Access Report

Date of Report: 18 April 2012

Re: Miranda Dental Hospital – 84-86 Kiora Rd Miranda

Assessment: Plans dated: 17/04/2012

Level 5 Floor Plan
scale: 1:100

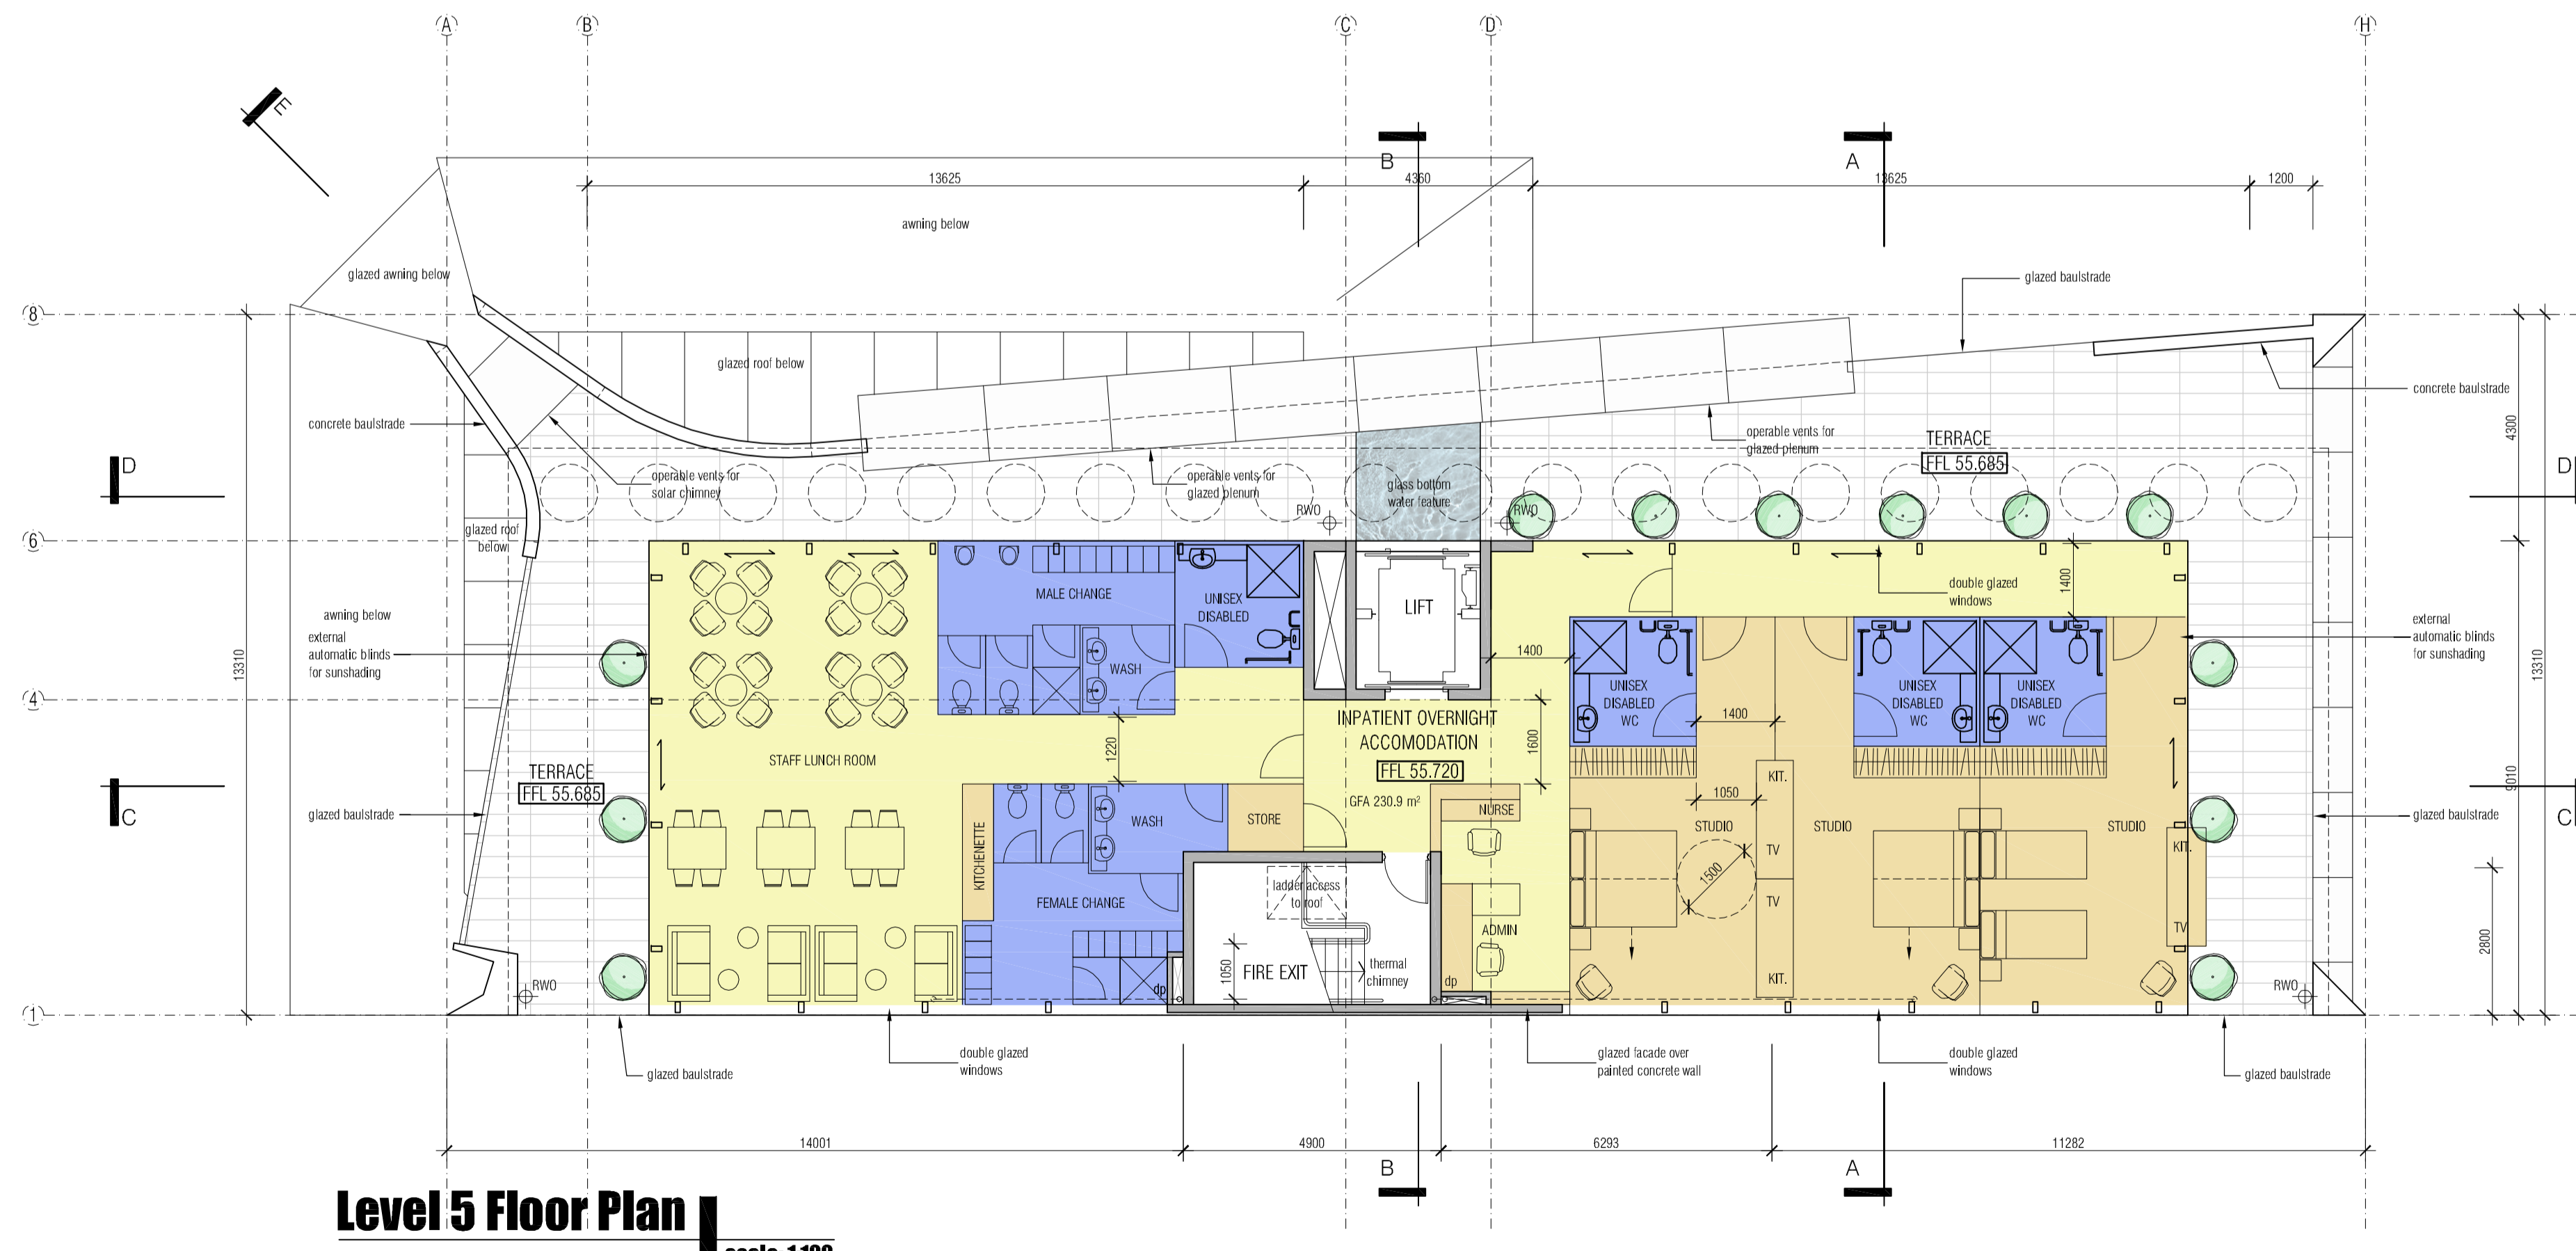
Comment: A chair rail, hand rail or transom may adequately indicate that the glazing is not a doorway or opening.		
g) Where there is a level change at a doorway such as the level 5 terrace doors, a ramped threshold is to be provided. It is to have a maximum length of 280mm, height of 35mm and gradient of 1:8. It is to be located within 20mm of the door leaf which it serves.	AS 1428.1 10.5 Fig. 21

Access elements	Reference	Re: Plans
8.17	An accessible shower is included in the staff and inpatient facilities on level 5. The accessible showers are to comply with AS 1428.1 including the following features:	<i>BCA Table F2.4b</i>	Not fully detailed on plans
